REVIEW RESPONSE

DATE: 7-14-2021

PROJECT NAME: SUN

Review Comments for File No. SHL20-044 and SEP20-023 Second Review Letter –
7240 N Mercer Way, Mercer Island, WA 98040;

EXISTING CONDITIONS

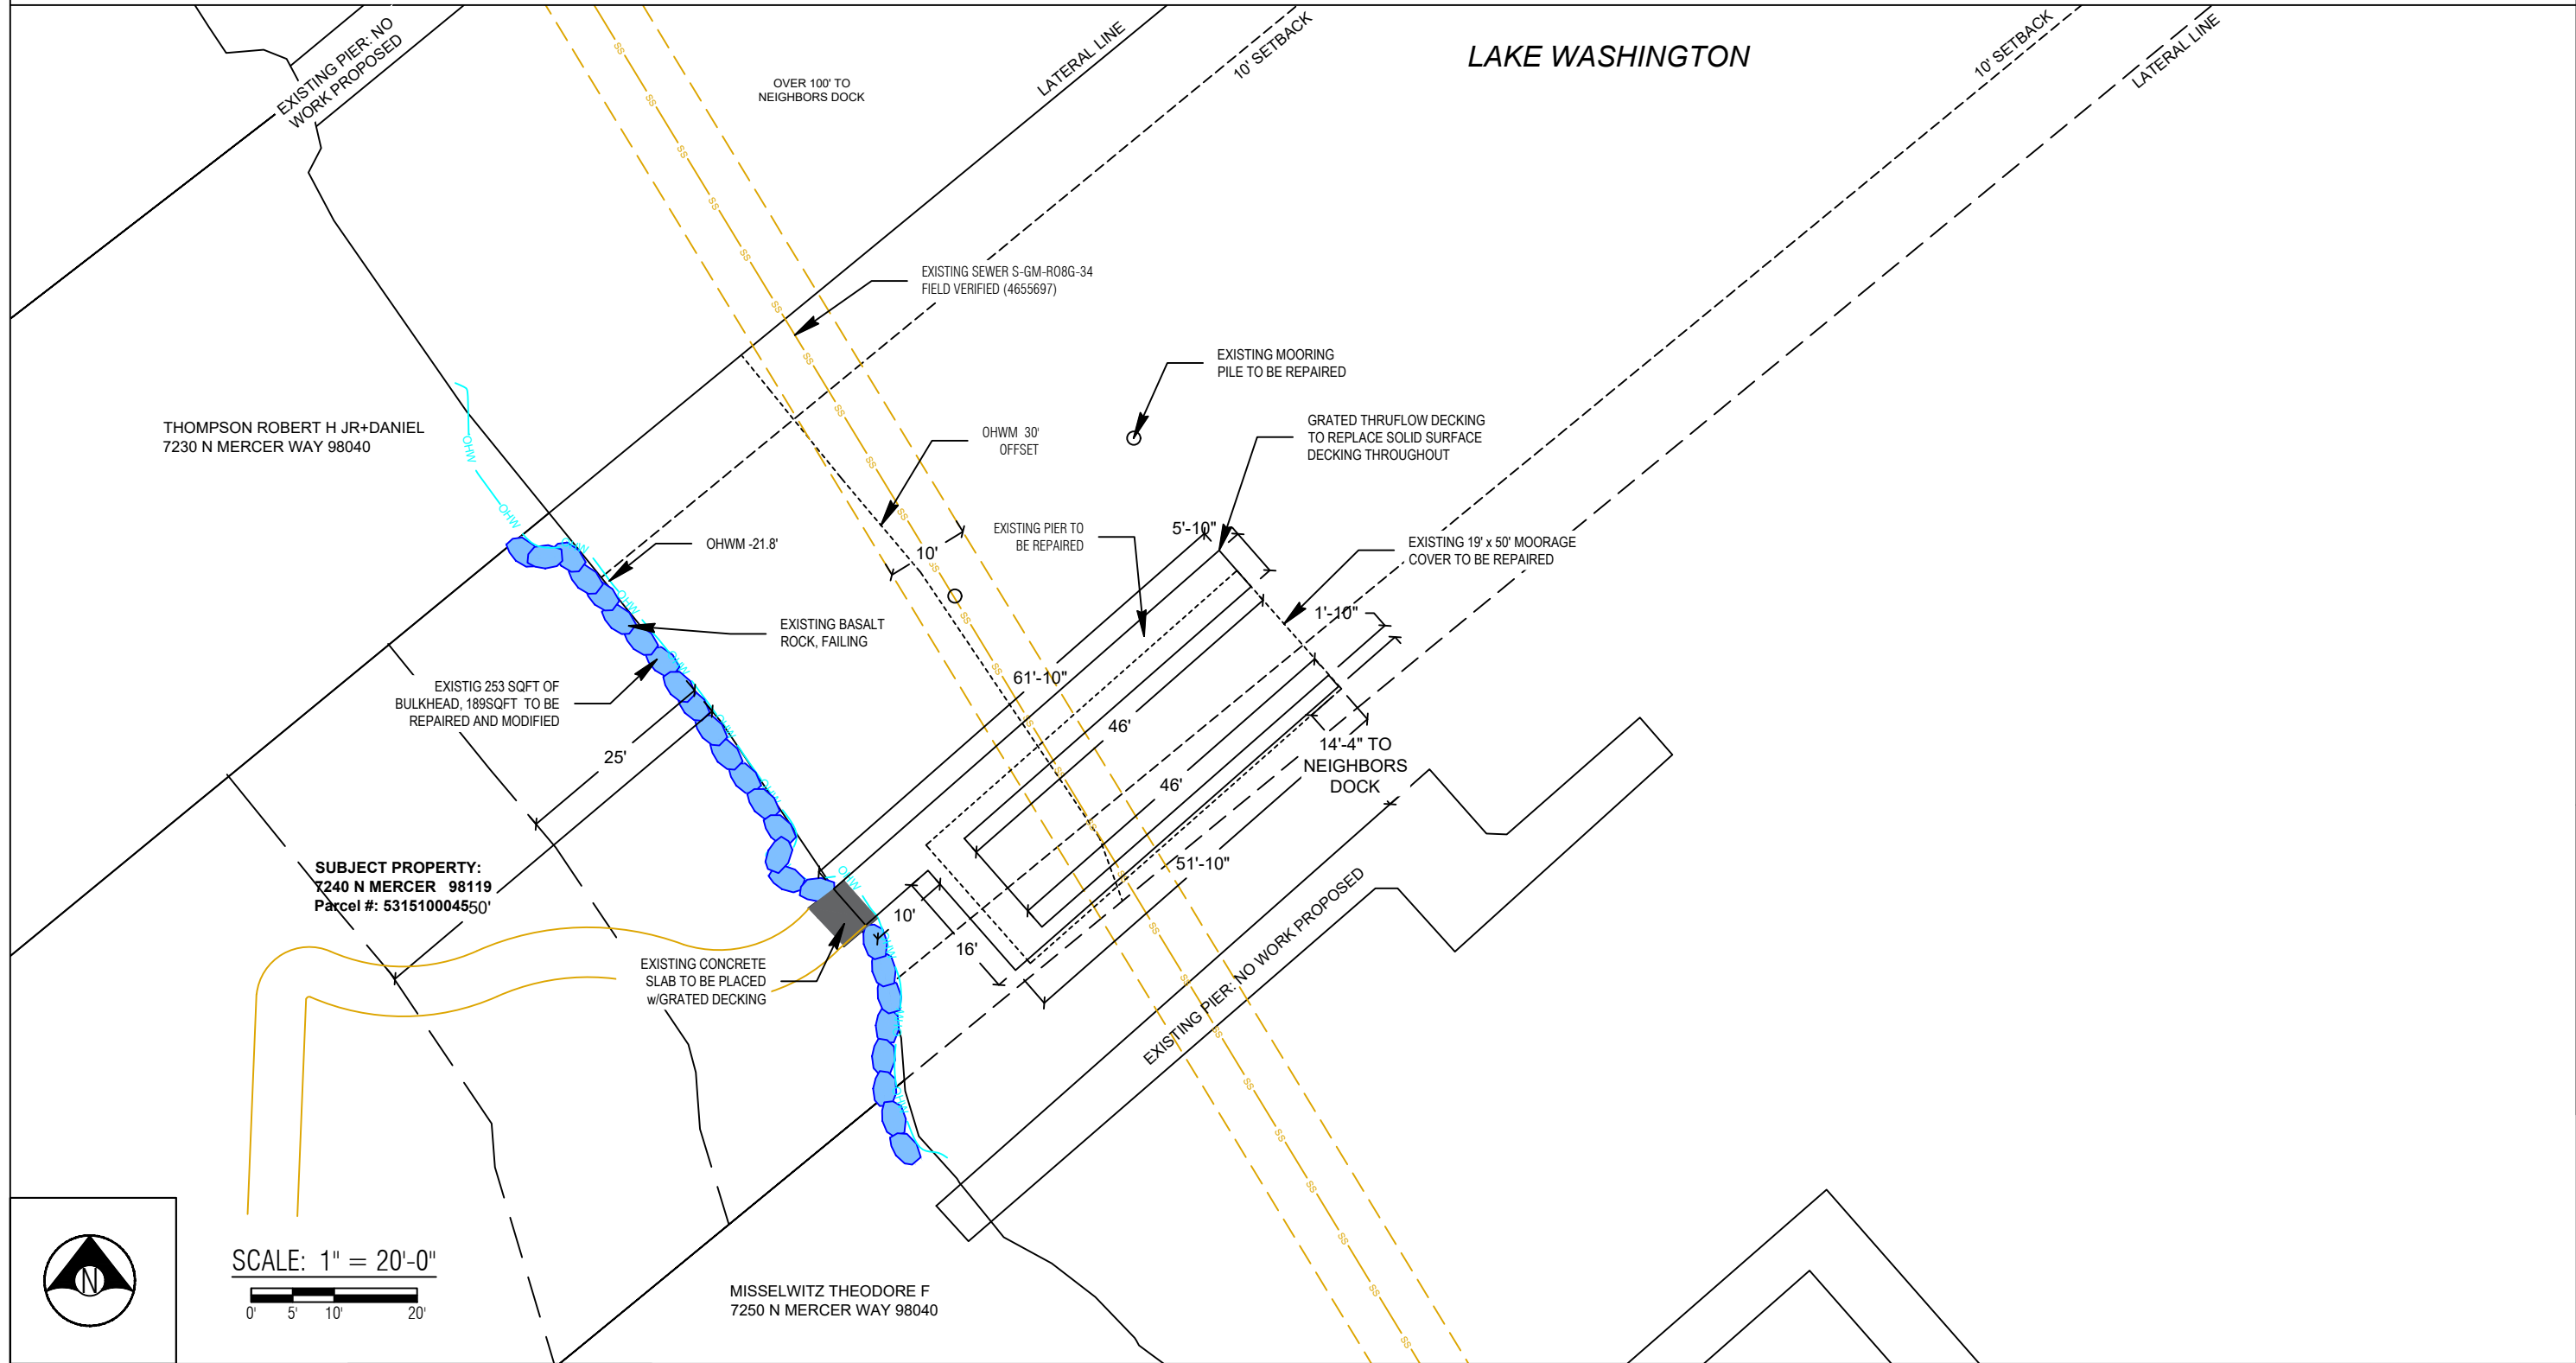
f. On the existing conditions sheet A2.0 please illustrate the existing bulkhead and label.

The existing bulkhead and proposed bulkhead have both been illustrated and labeled on the revised site plan

PROPOSED CONDITIONS

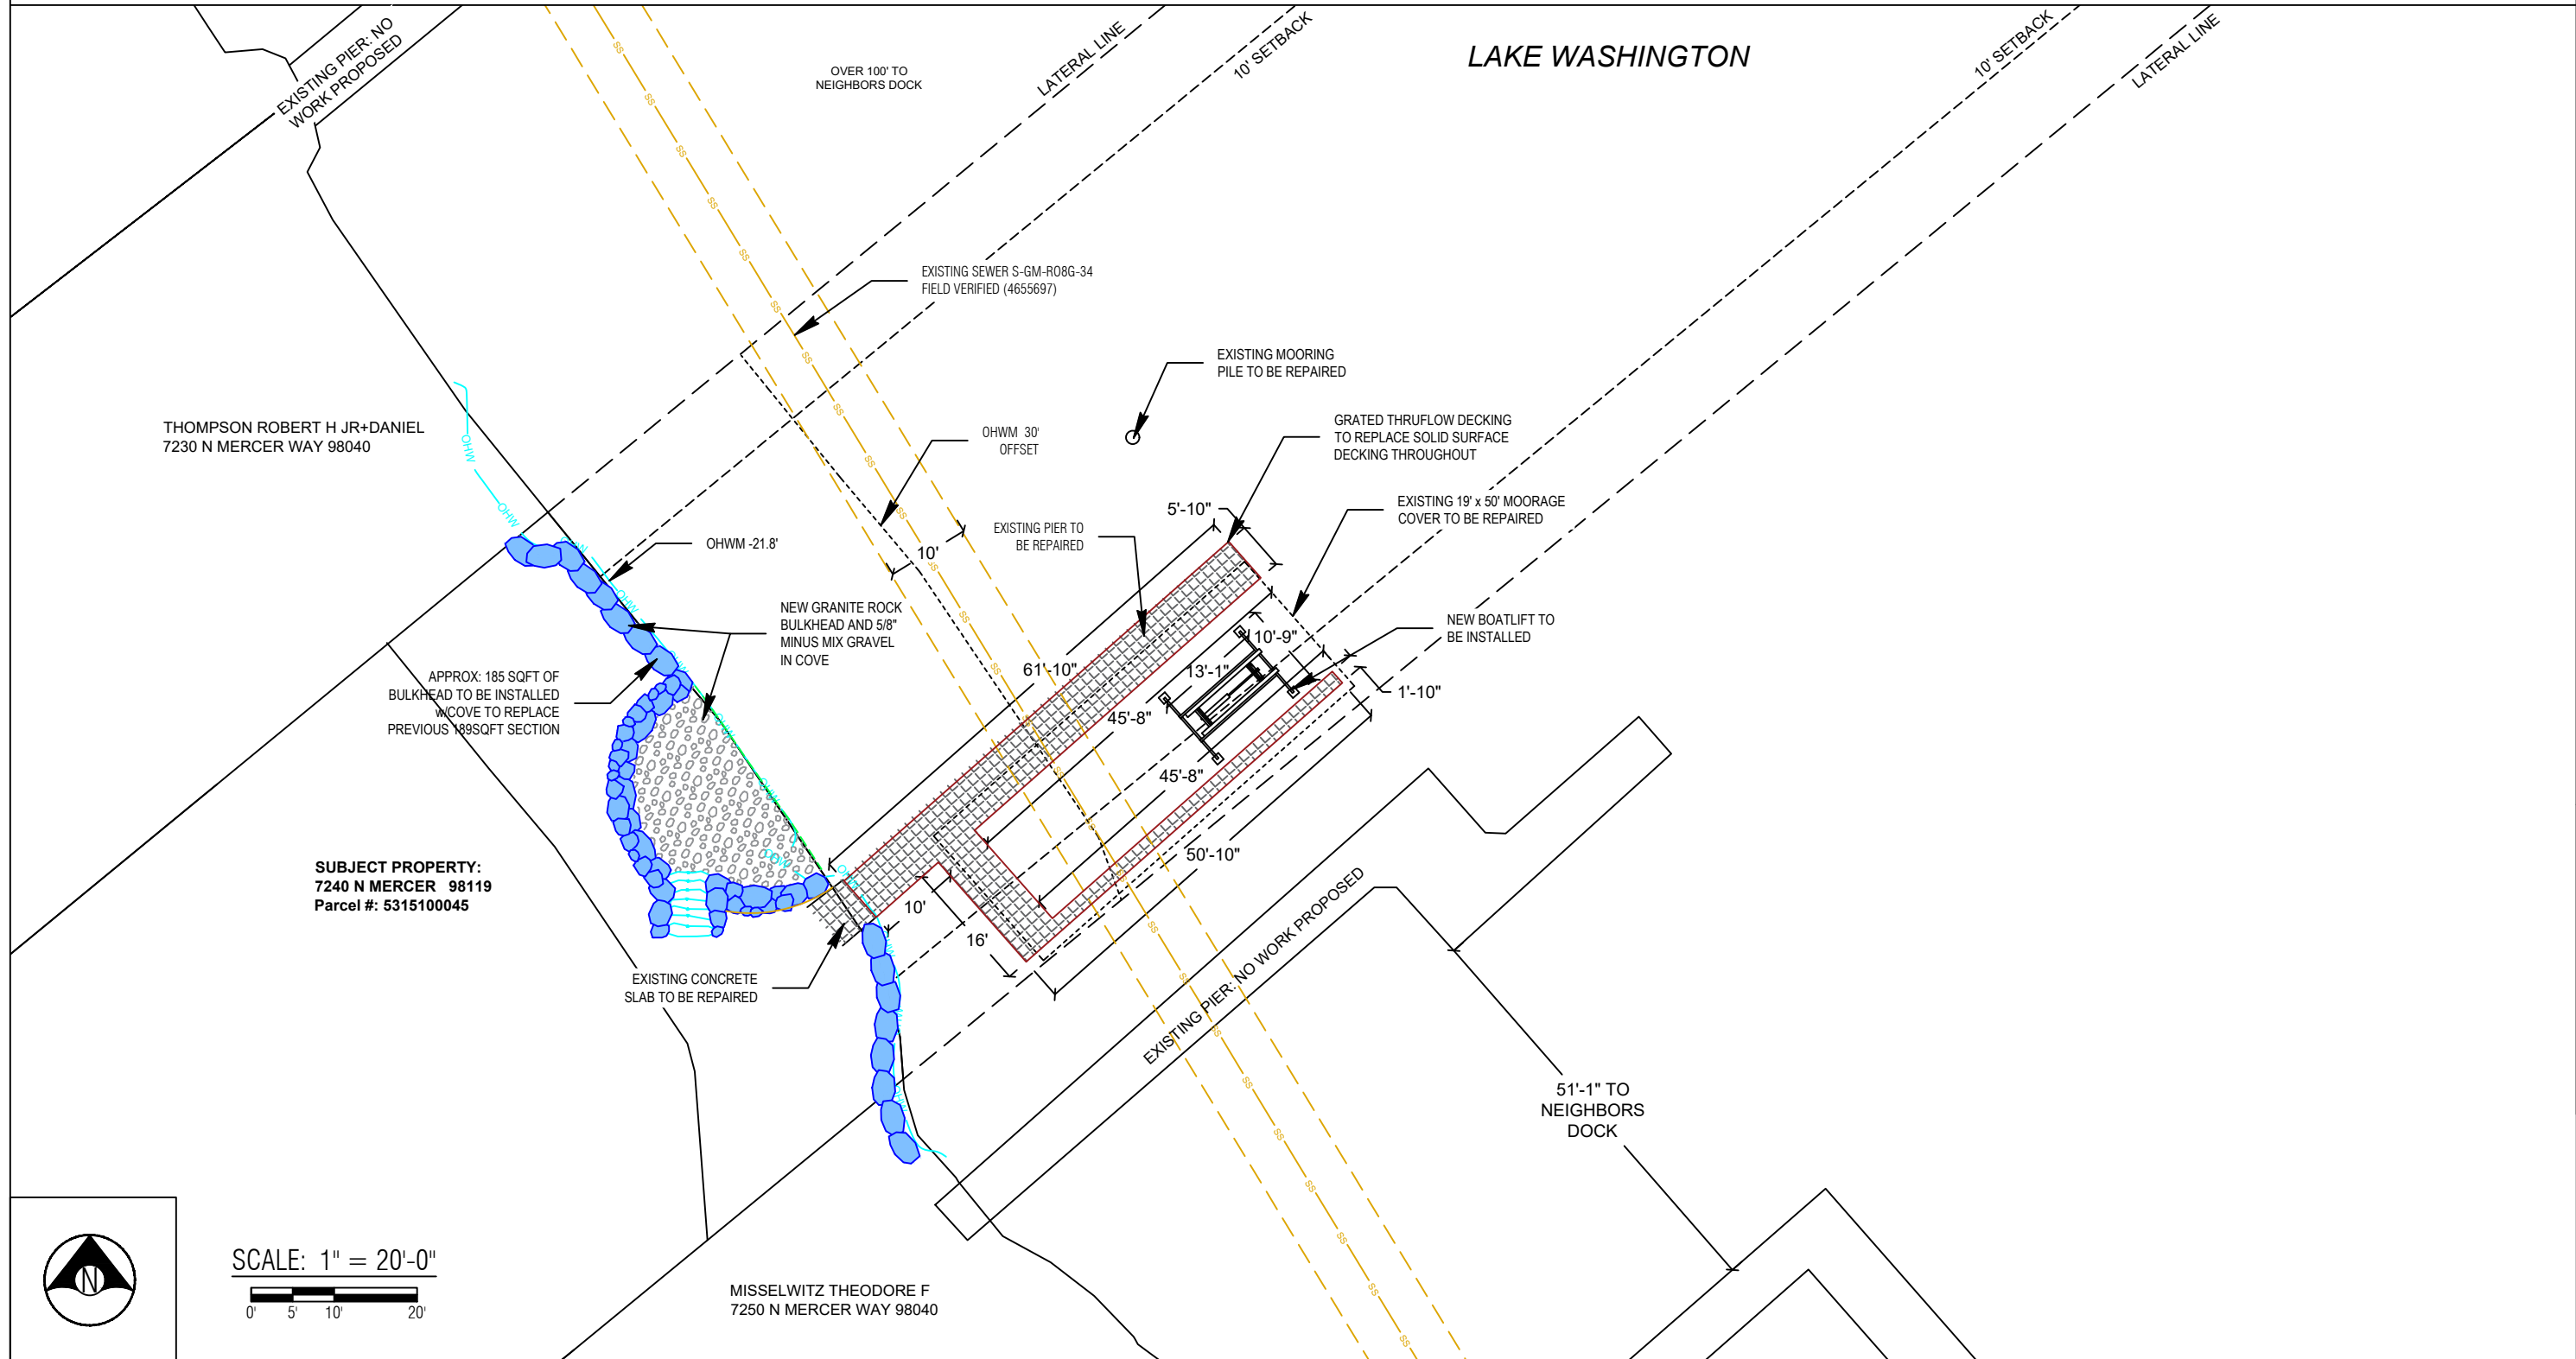
d. The proposed boatlift needs to be located outside the city sewer easement. No structure shall be constructed on or over any easement for water, sewer, storm drainage, utilities, trail or other public purposes unless it is permitted within the language of the easement or is mutually agreed in writing between the grantee and grantor of the easement.

Boatlift location has been updated to show the lift outside of the easement

1 COBBLE BEACH COVE – SECTION
SCALE: 3/8"=1'-0"

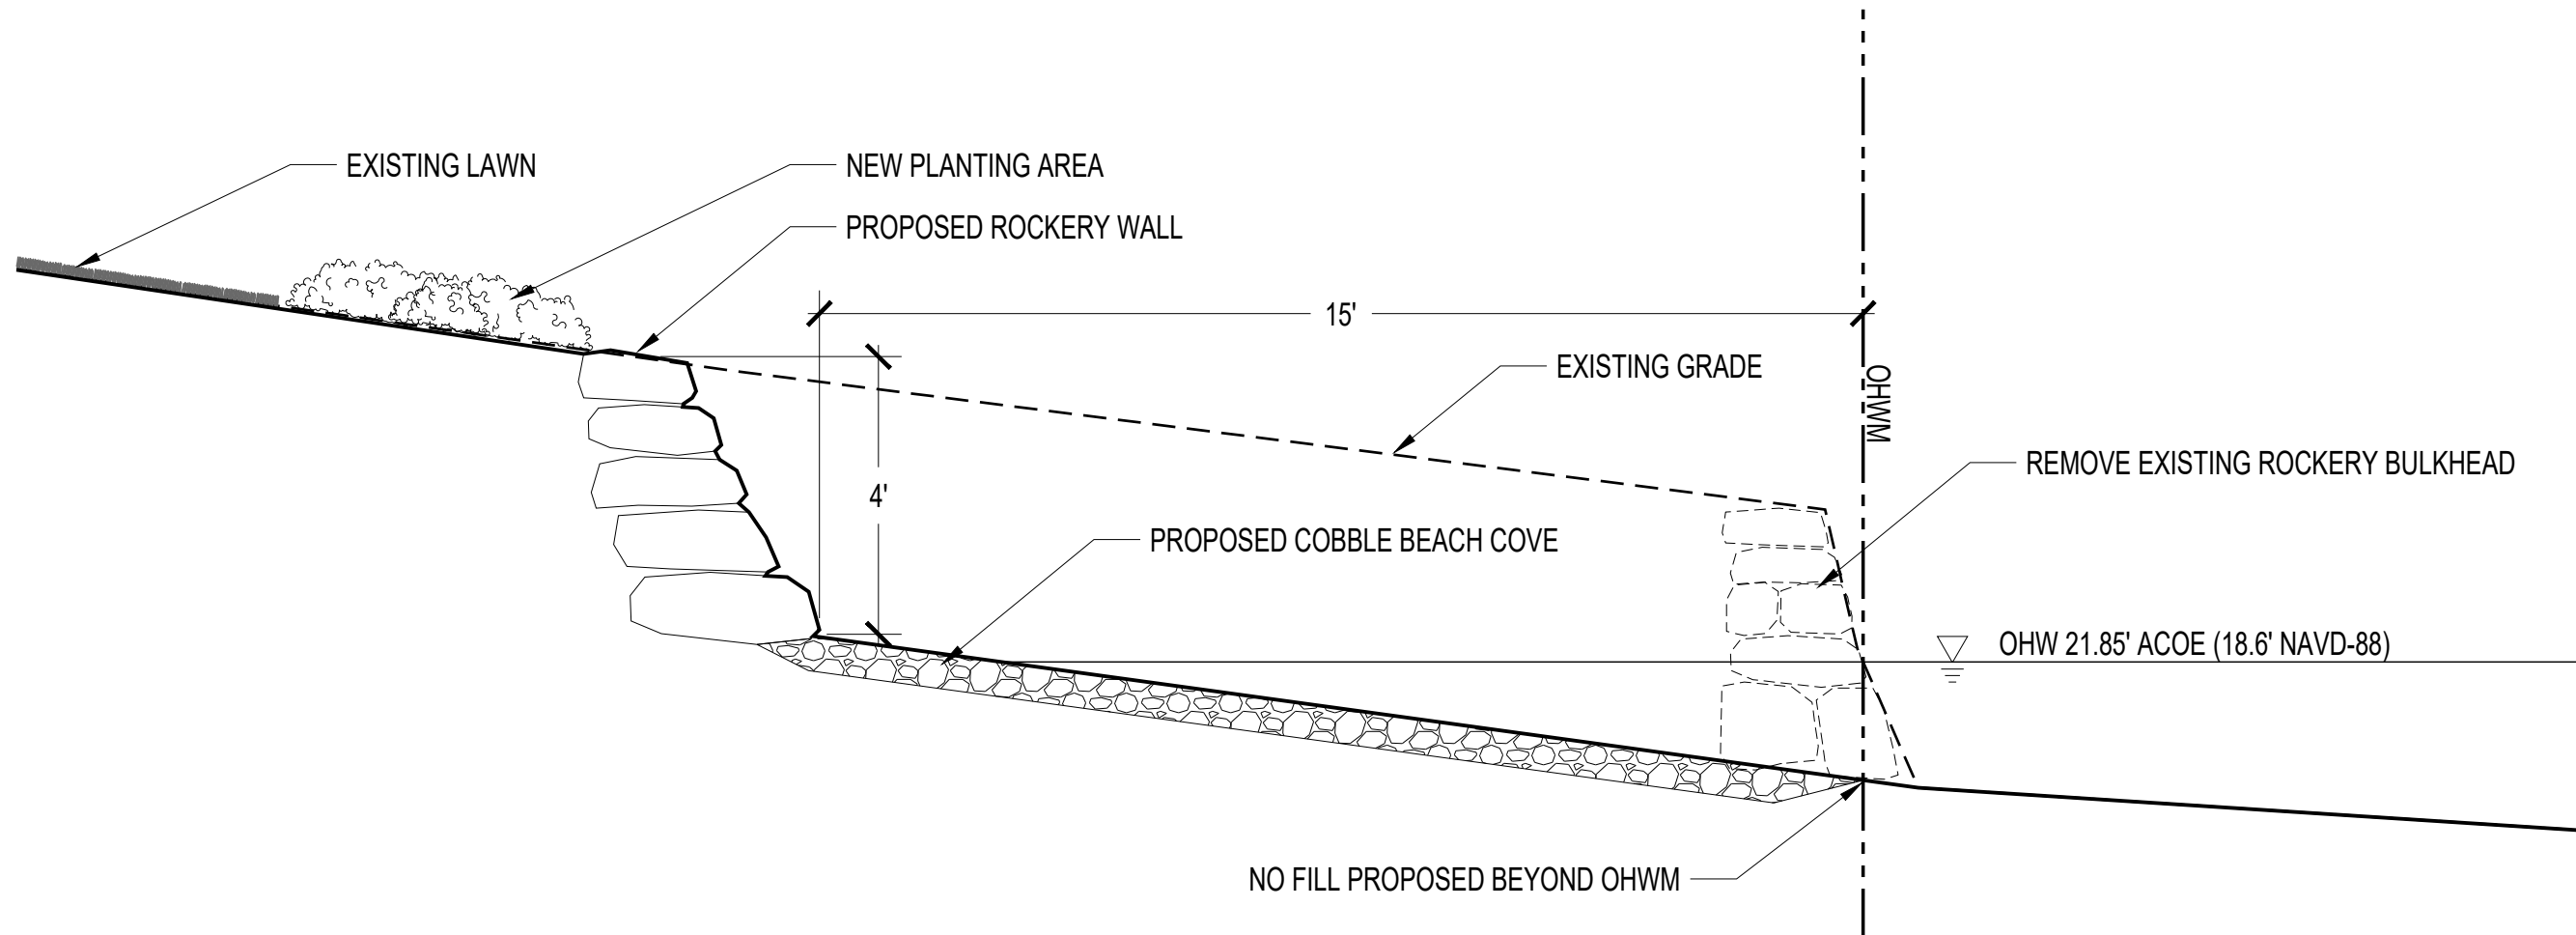
a. Please label on all sheets what material will be used to fill in the proposed cove. Is it spawning gravel/pebbles?

Spawning gravel will be used to satisfy the WDFW requirements @ 5/8” minus mix
